PINs Registration and Relevant Representation Form on behalf of Historic England

Project : Stonestreet Green Solar Farm

TR010032

A solar farm of 192 hectares is proposed on agricultural land within the Upper Stour valley near Ashford (south of M20) in Kent. The proposal includes on-site energy storage, associated infrastructure, an underground cable connection to a nearby substation, screening through planting and a series of off-site landscape improvements.

DRAWING TITLE  
**FIGURE 7.1B:  
DESIGNATED HERITAGE ASSETS WITHIN 5KM OF  
THE SITE**

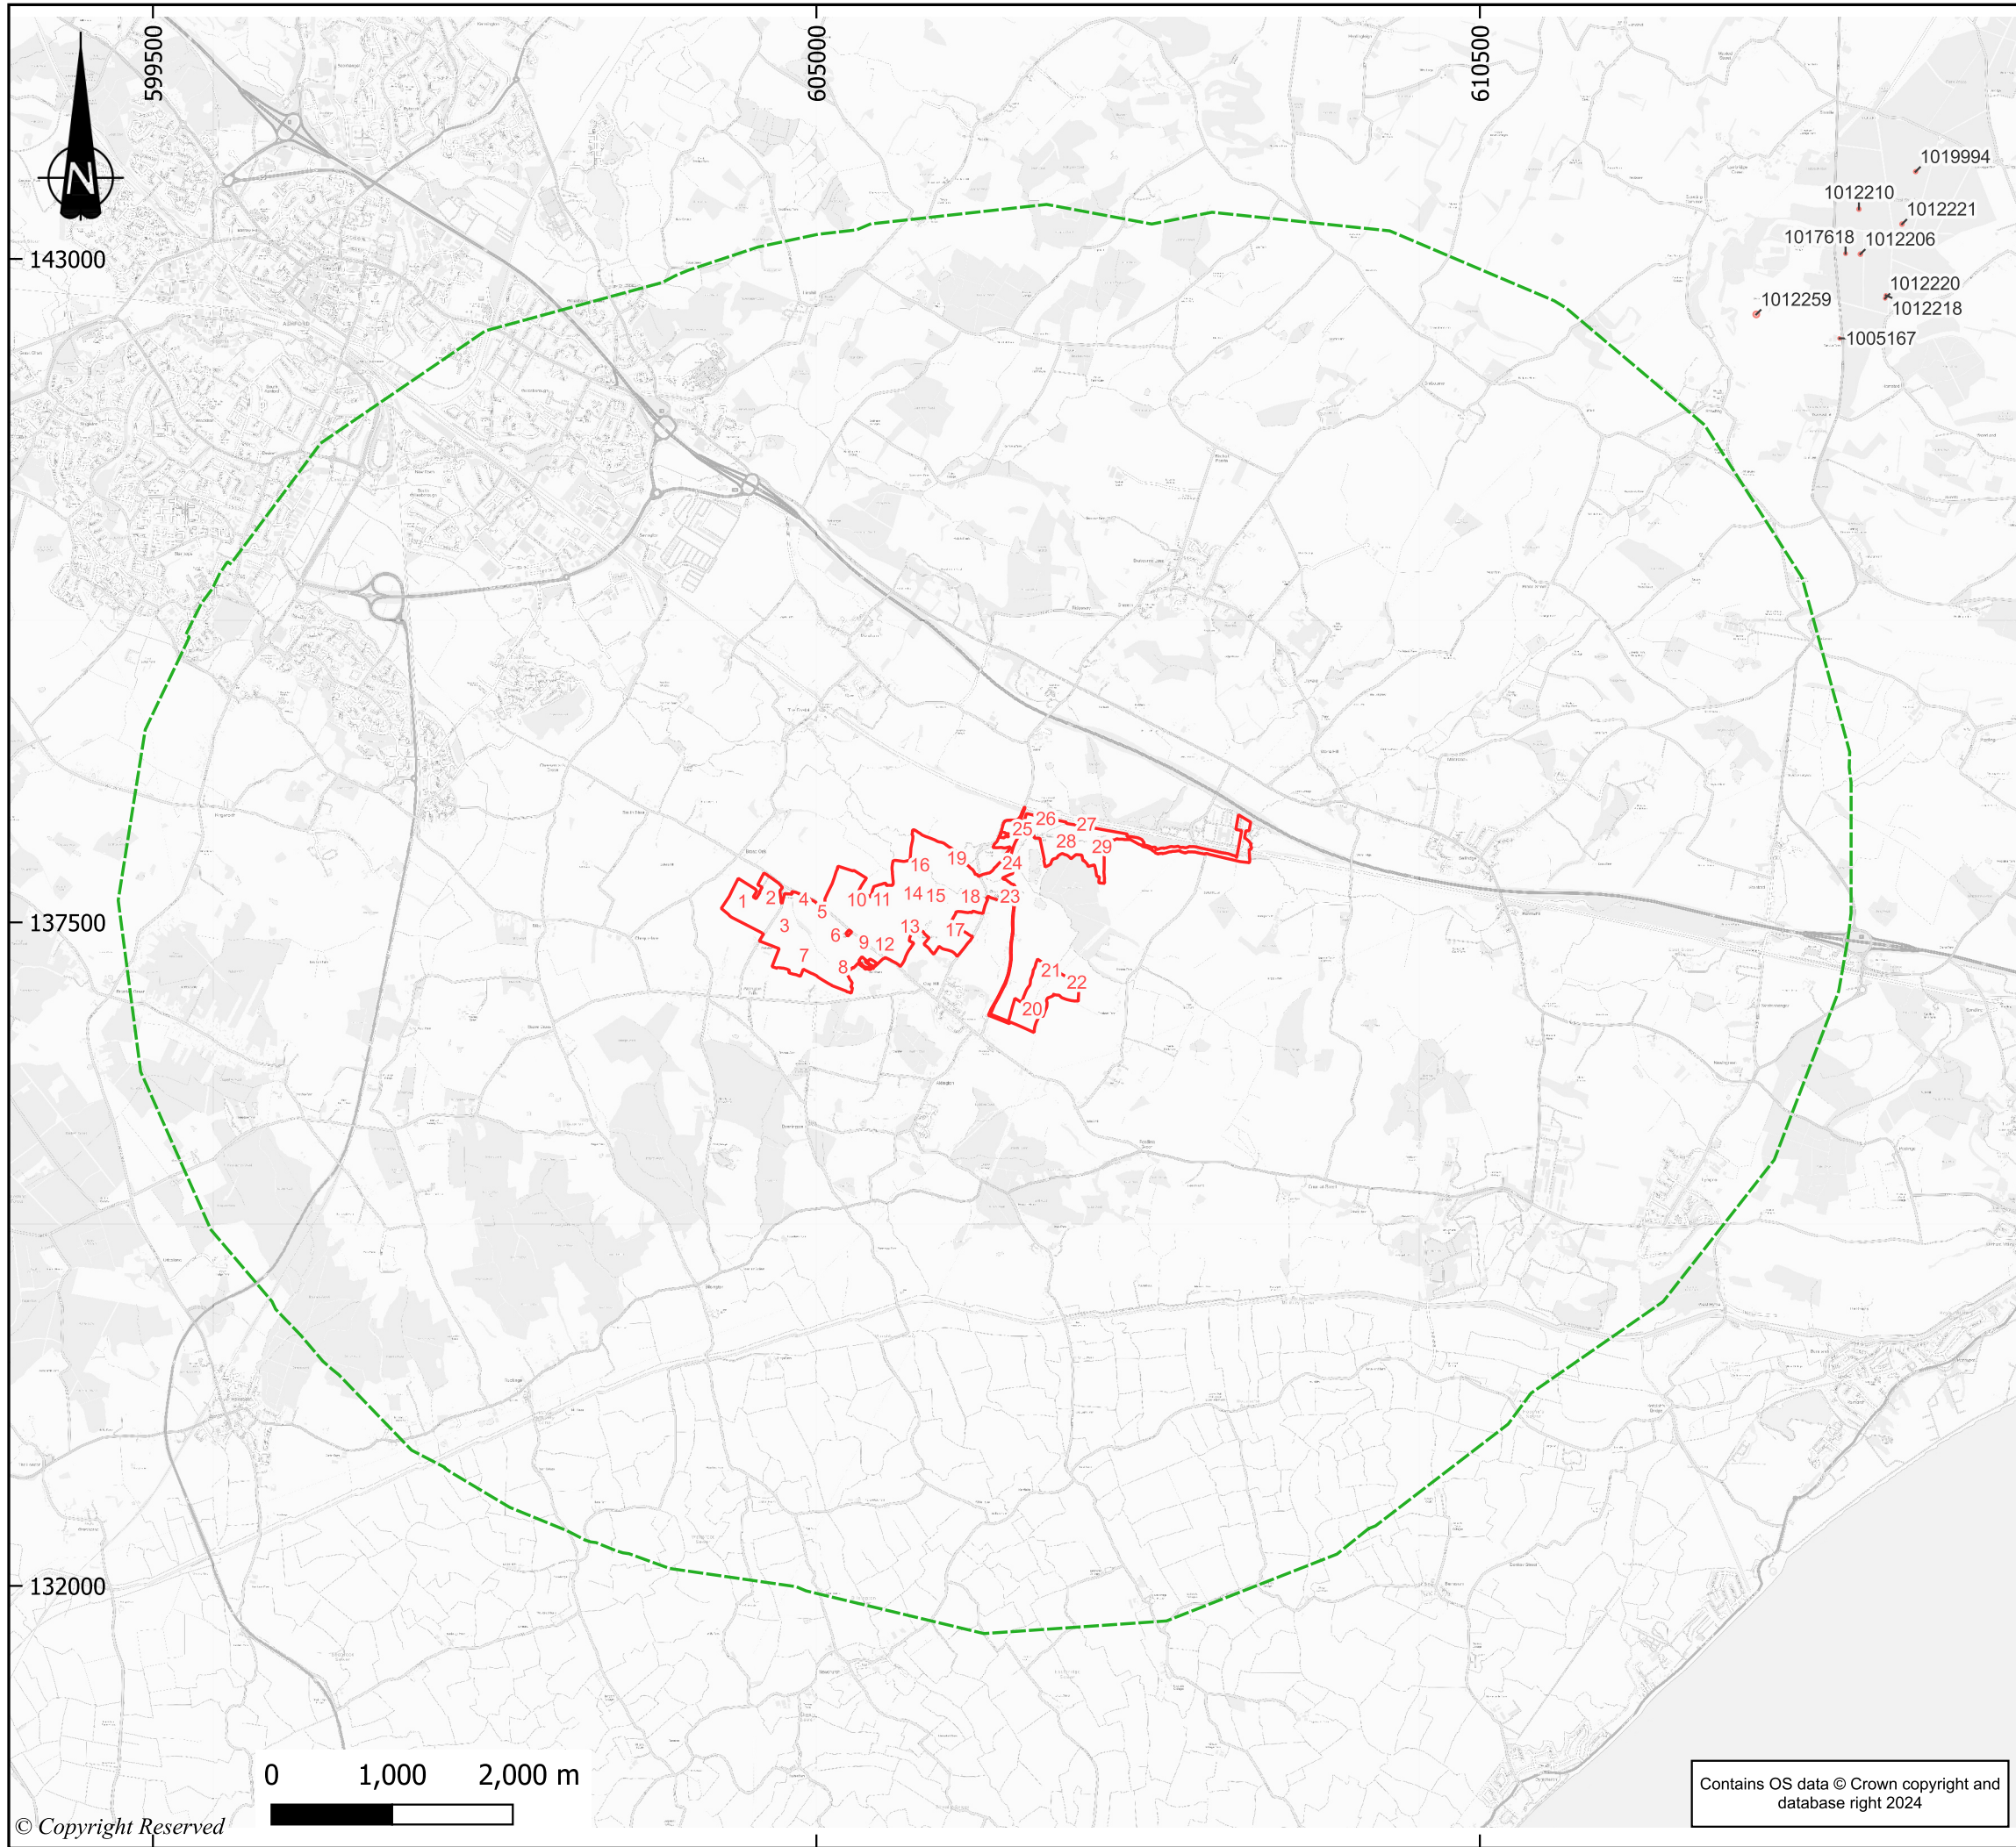
Our primary consideration in relation to this scheme is the impact upon the significance of the Church of St Martin in Aldington, the Church of St John the Baptist in Mersham, Stonelees House and scheduled (and unscheduled) Bronze Age barrows through development within their setting. We would defer advice on grade II listed buildings and conservation areas to the local planning authority (Ashford Borough Council) but will comment on the assessment of the grade I and II* listed buildings and scheduled monuments.

We have identified harm to the significance of the Church of St Martin, Aldington (Grade I: NHLE 1071208) a Saxo-Norman parish church listed on 10 August 1988. The church is set on a small hill with an architecturally exceptional medieval tower that acts as a landmark in the landscape. The open fields within the application site contribute positively to the significance of the church and add to historic value as the location of the church with its surrounding fields means it is at the heart of the agrarian community who built and worshipped there. This appreciation would be altered in a key view of the church from the west by the presence of solar panels. The fields (and footpath) also act as an important land buffer showing the historic separation between church and village and this landscape separation would be eroded to a small extent by the proposed development. We therefore consider that the proposal would result in a low level of less than substantial harm to the significance of the church through this

We have identified harm to the Church of St John the Baptist, Mersham (Grade I: NHLE 1276693), a twelfth century parish church from which was listed on 27 November 1957. It is situated on rising ground to the north of the site and can be seen from some views at the edge of Aldington Clap Hill Conservation Area (view 11). Whilst the tower is screened by some trees, the fields provide a countryside setting for the church which contributes to its significance as a rural place of worship and focal point in the landscape. This would be eroded to a small degree by the proposed development. We judge harm to be at the lower end of less than substantial.
